RE: Lot 3 Block 4 Unit 19 Volcano Cliffs Subd.

6548 Azor Ln NW

Request for Permanent C.O. - Accepted Engineers Stamp Date 7/9/15 (D10D003T3)

GRADING & DRAINAGE PLAN 6548 Azor Lane, NW LOT 3, BLOCK 4, UNIT 19 VCS

GRADING AND DRAINAGE PLAN
LOT 3 , BLOCK 4 , UNIT 19 , VCS
ADDRESS: 6548 AZOR LN NW

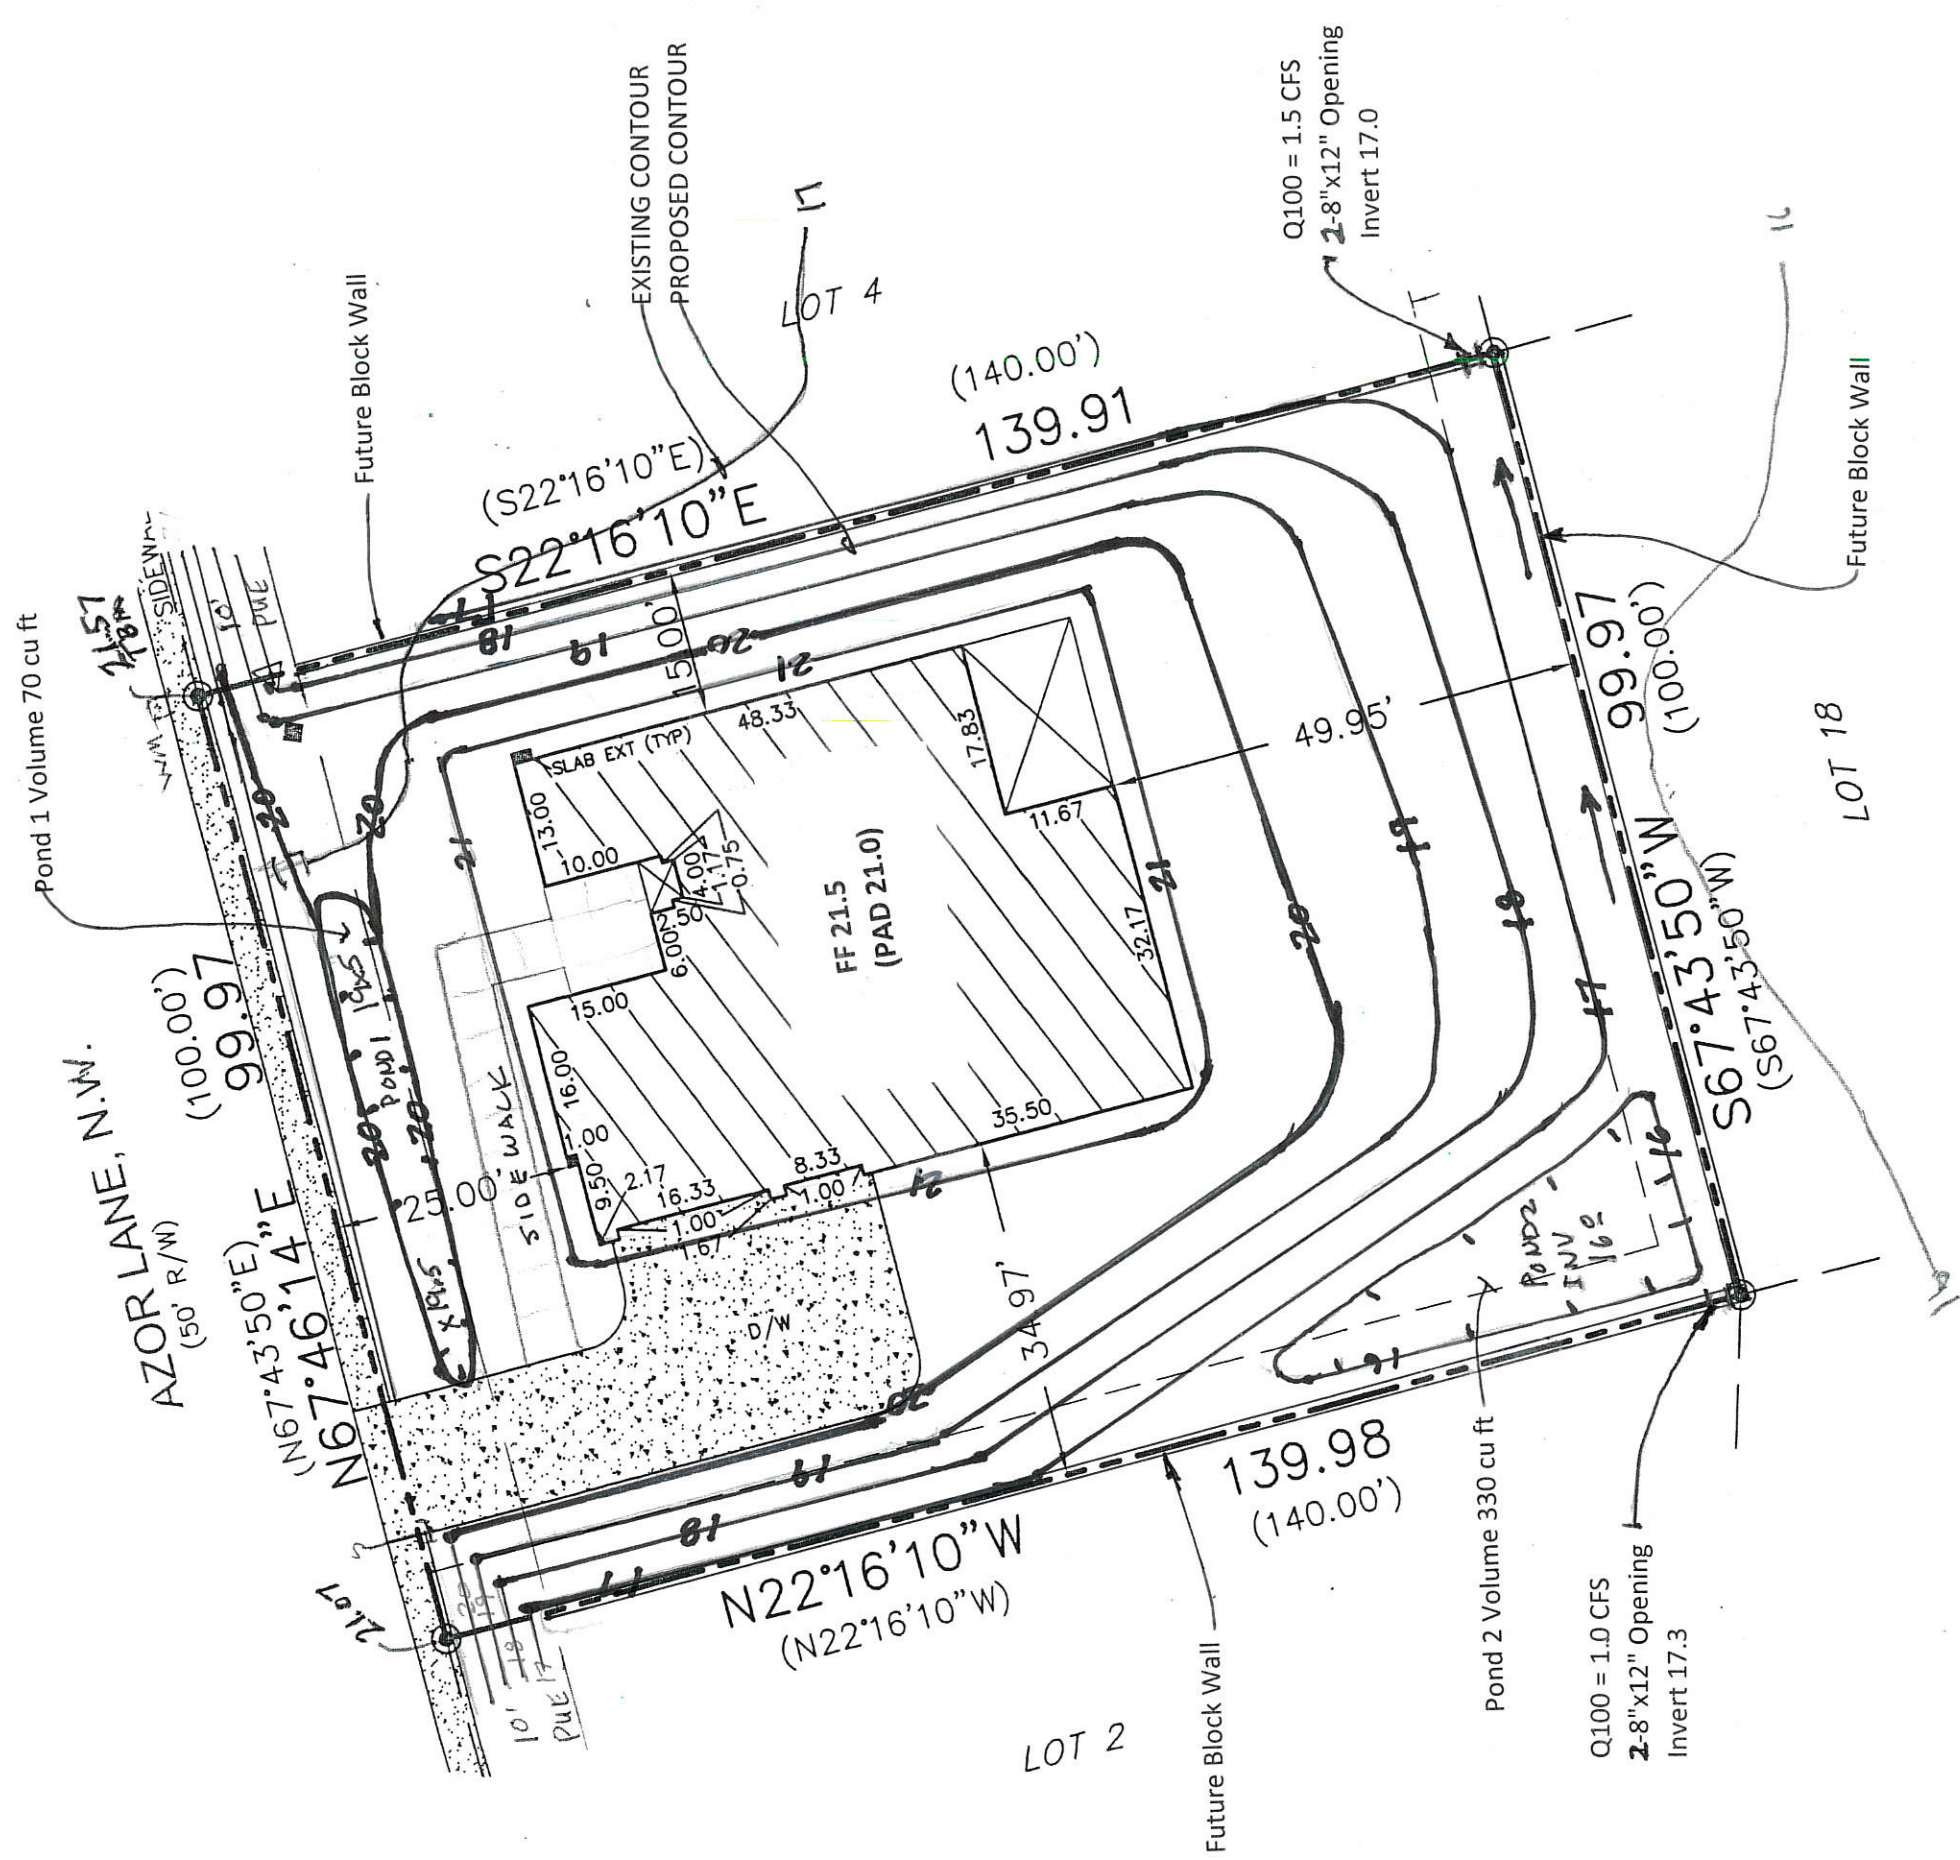
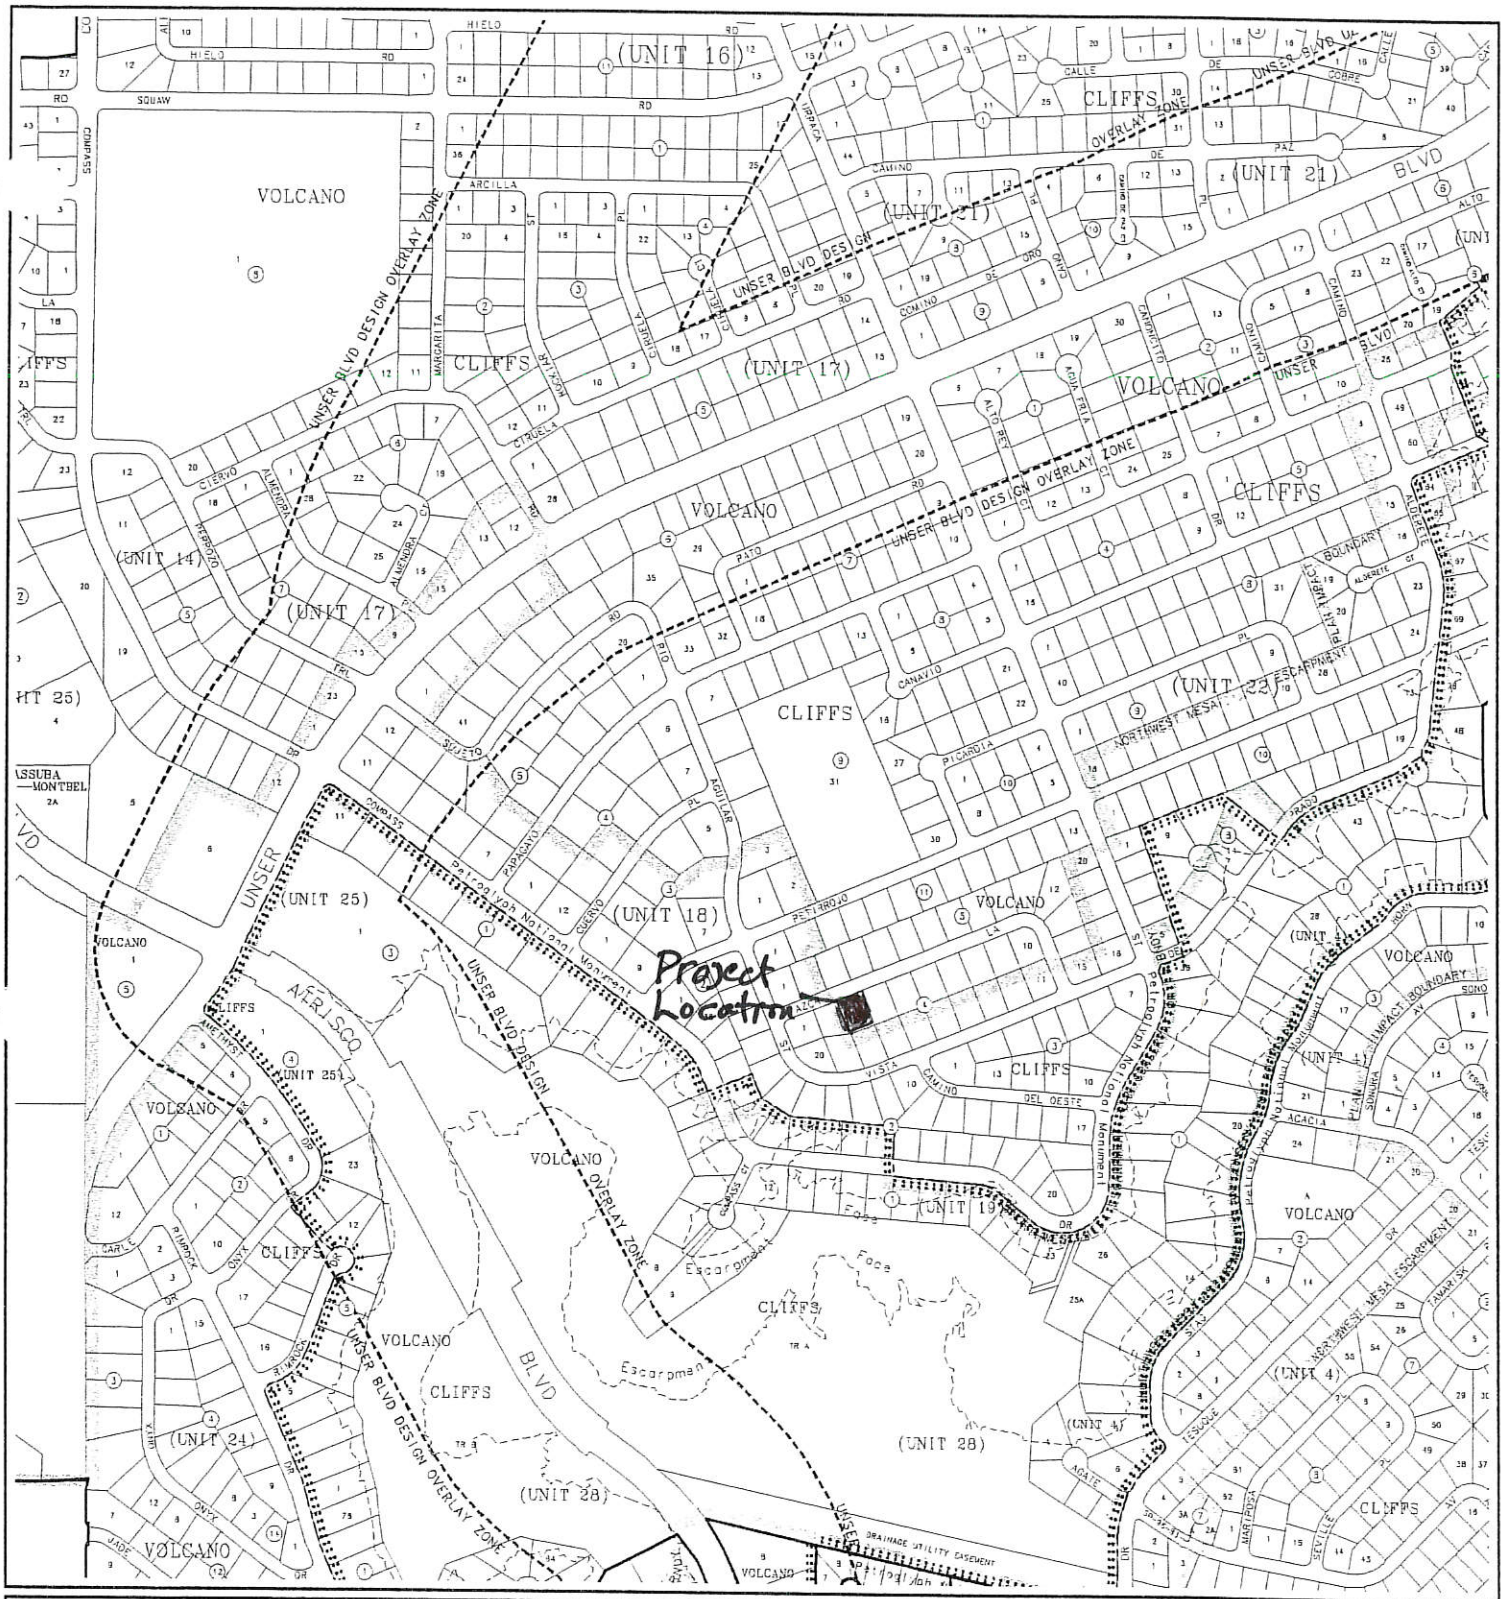
Provide flows for this property which exit out to Azor Street.

Remove block openings.

Provide swales from rear yard to front yard both sides of structure.
